DELEGATED DECISION TO DETERMINE PLANNING APPLICATIONS

Reference No:	2025/62/92897/W
Site Address:	49, Bank End Lane, Almondbury, Huddersfield, HD5 8ES
Description:	Erection of two storey rear and side extensions, single storey front extension, rear balcony and alterations to driveway and access
Recommending Officer:	John Holmes

DECISION – Full Conditional Permission

No.	Date	Dr	Description
scale	As indicated	drawn	PSI
date	SEPT 2024	path	G:\Architectural\Jobs\2356 - Bank End lane, Almondbury\Arch\Existing\2356 - existing.rvt
status			PLANNING
job no	2356	dwg no	A(00)-02
		rev	LG

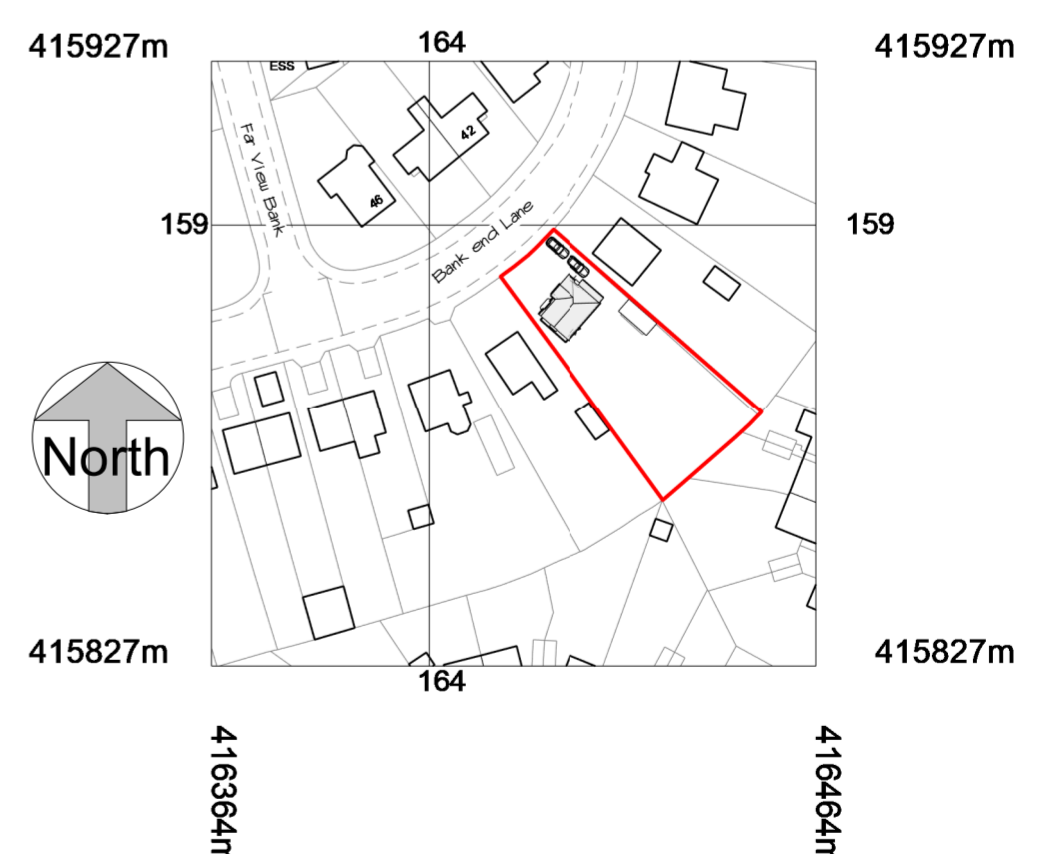
This would see additional hardstanding and widening of the access by removal of the front boundary wall and some of the soft landscaping to the front amenity space to provide parking for 4.no vehicles. The space from the front of the porch to the rearmost part of the pavement is shown on plan A(90)-02 to be 5.6m (for the majority of the space to the front of the porch).

The submitted plans demonstrate alterations to the access, creating 4 spaces. The Council's Highways Design Guide specifies a distance of 5.6m be achieved from the back of the highway for a usable driveway. This distance would be achieved by the proposed development for the majority of the driveway.

Notwithstanding this, it is clear that a tandem parking arrangement is also possible with cars parked horizontally across the frontage such that the area to the frontage is able to be utilised for the parking of 3 vehicles.

| No. | Date | Dr | Description | apprv |
|--------|----------|--------|---|-------|
| job no | 2356 | dwg no | A(10)-03 | rev |

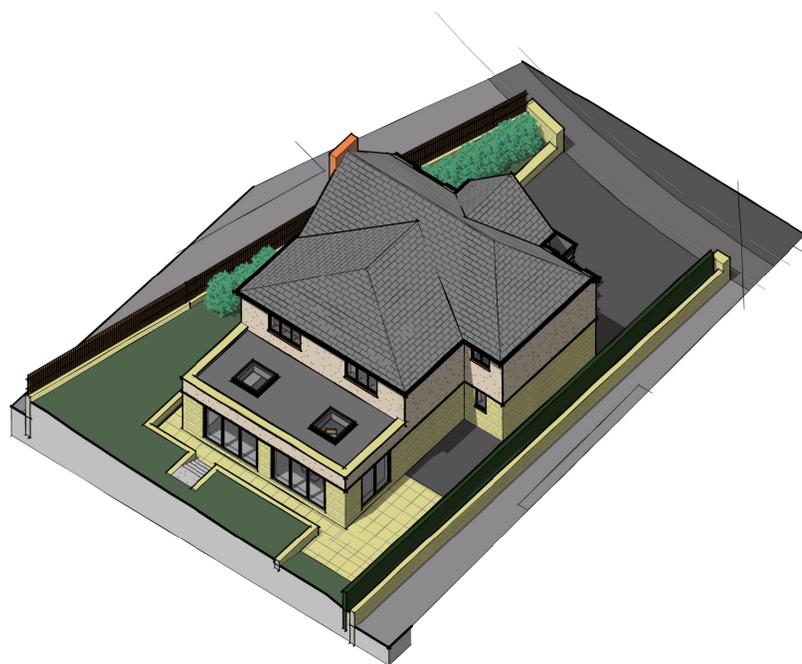
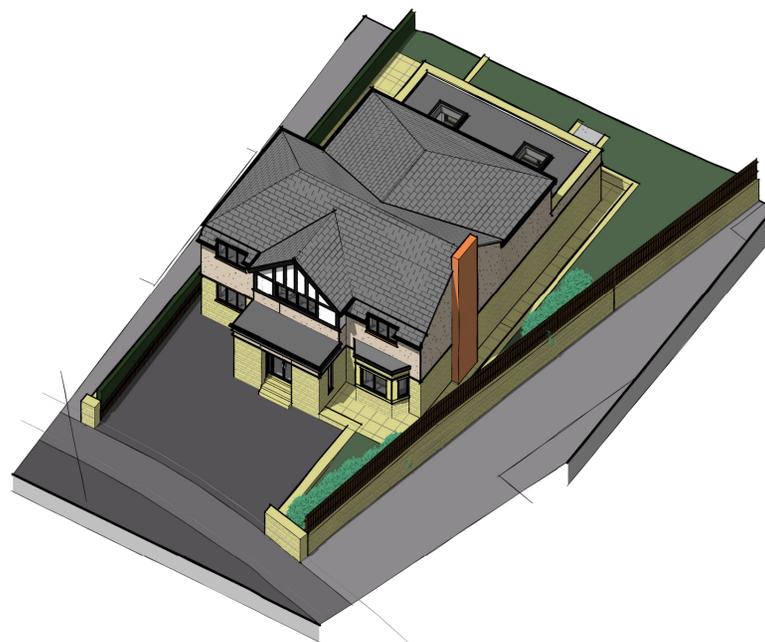
This would be a 3m projection from side, 5.1m to eaves with a hipped roof design typing into the side of the existing roof (ridge height 8.5m). This would be set back 0.6m from the front elevation and have a depth of 6.3m.

This would be 8.9m spanning across the rear of the dwelling with a 4m projection. The single storey element would have a parapet flat roof 3.2m in height and would be between 4m and 8m in terms of its projection from the rear of the host property. The height to the eaves of the two storey element would be 5.2m and height to the ridge being 7.5m.

The single storey element to the rear is largely the same as that permitted by application 2025/92310. The two storey extension to the rear meets the recommendations within the SPD in terms of its dimensiona. Similarly, the two storey side extension would be in compliance with the recommendations of the SPD.

The building would have a large increase in size and footprint, however when viewed from public vantage points to the front this would read as visually harmonious and subservient given the set back of the two storey side element and the layout of openings being in-keeping with the proportions of those of the host property.

The side elevation (ground floor level) of no.47 features a window. This would be directly opposite the two storey side extension. Notwithstanding this point, given the predominant orientation of no.47 is served by openings to the front and rear, the impact of the existing building and distances which would remain, it is concluded that refusal on grounds of impact to this side openings serving no.47 could not be substantiated in this case and on balance the proposal is acceptable.

It is concluded that the impact of the development in relation to overshadowing would be acceptable, this is having regard to the fact the proposal would not cut a 45 degree line when taken from the centre of the eill of the front / rear openings to no.47 and no.51.

3. The materials of construction used to all external walls and the roofing materials of all pitched roofs of the development hereby approved shall in all respects match those used in the construction of the existing building, be in the locations as set out in submitted drawing A(10)-03RevC and be retained thereafter.
